From: Adam Humphrey [REDACTED]
Sent: 30 May 2019 06:36
To: Sian Eggington
Cc: Mel Humphrey MRICS Rics
Subject: Re: Further Information Required on Your Ref: PP-07876269 Our Ref: R/114/19/HH
Attachments: 2 Amberly Road.pdf

Your Ref: PP-07876269 Our Ref: R/114/19/HH

Site plan 1:500

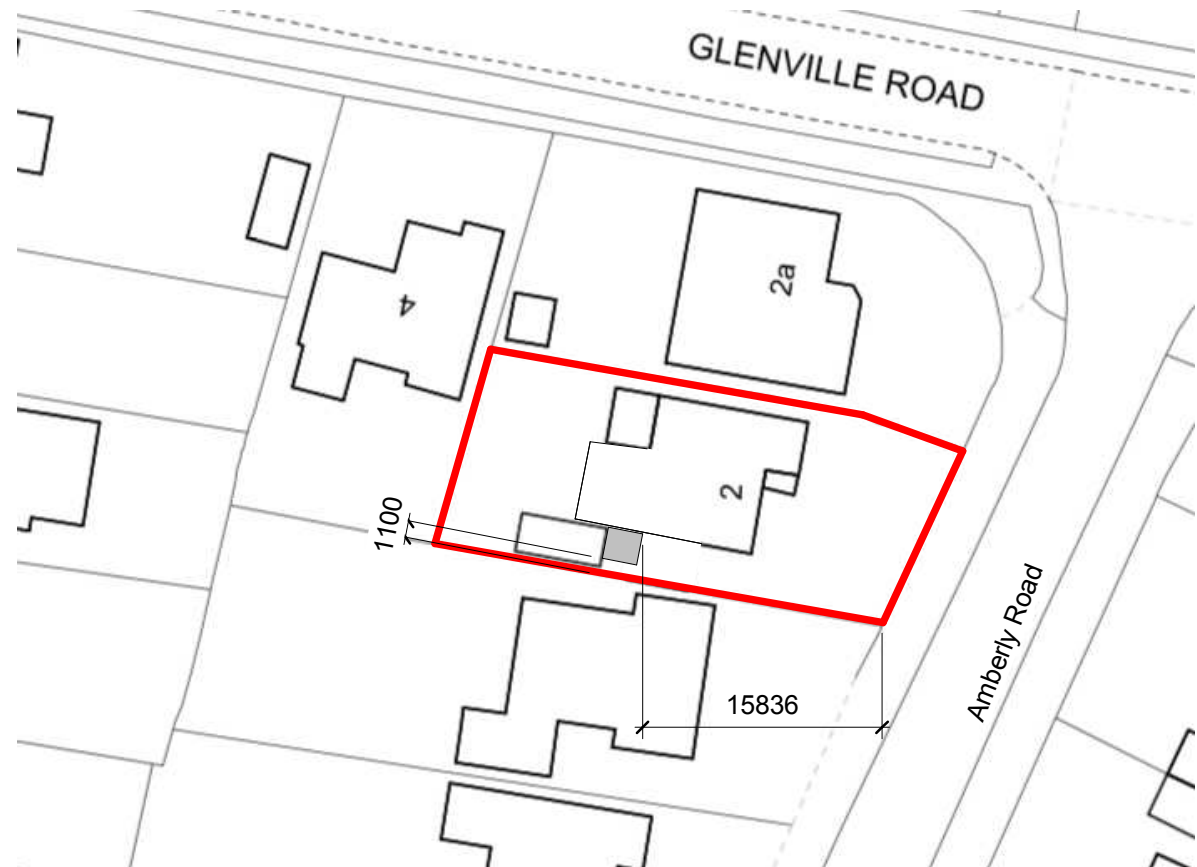
Thank you for your email, however the issue still remains. It is a local requirement for Arun council that you are required to have dimensions on your block plan from the proposed extension to the site boundary. In this case a dimension is required from the extension (shaded area) to the side boundary and from the extension to the front boundary(pavement).

Revised drawing attached as requested with a dimensioned block plan.
